# CITY OF ALBUQUERQUE

**Re: Sandia View Cottonwood**  
**10401 Vista Del Sol Dr. NW 87114**  
**Traffic Circulation Layout**  
Engineer's/Architect's Stamp 12-10-18 (A13D023)

Based upon the information provided in your submittal received 12-18-18, the above referenced plan cannot be approved for Building Permit until the following comments are addressed:

SHEET NUMBER:
TCL-101

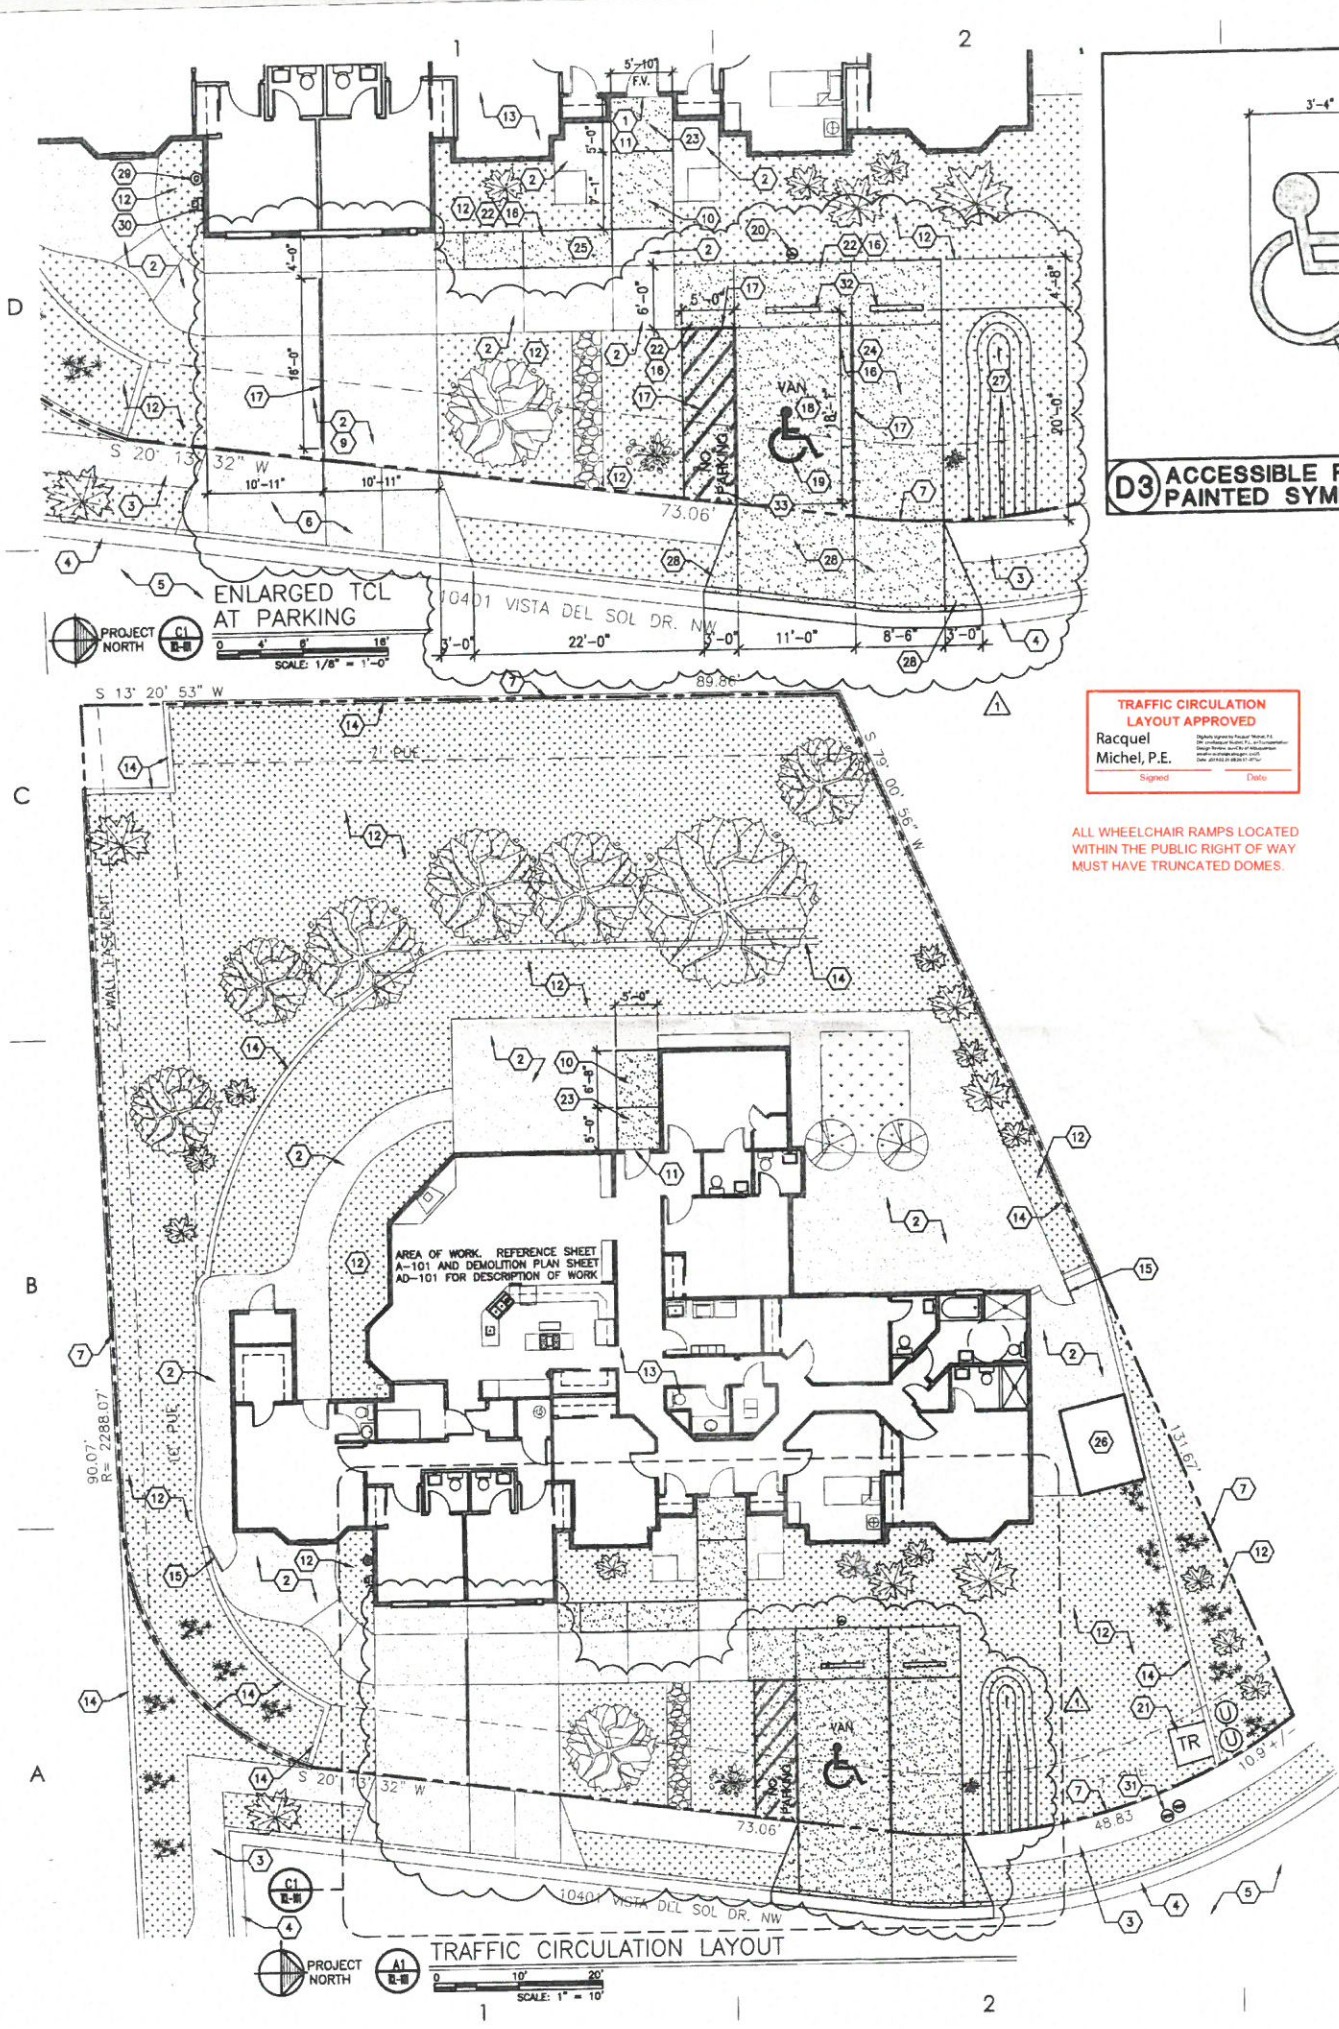
1. The ADA access aisles shall have the words **"NO PARKING"** in capital letters, each of which shall be at least one foot high and at least two inches wide, placed at the rear of the parking space so as to be close to where an adjacent vehicle's rear tire would be placed. (66-1-4.1.B NMSA 1978)
2. The minimum distance between two drives on one lot is 22' of full height curb. ( 6' is necessary for two curb height transitions for a total of 28' between the two drive pads. ( The width of drive allowed is 12' to 22") Please dimension width of drive pad.
3. Please include one copy of the traffic circulation layout at the next submittal.
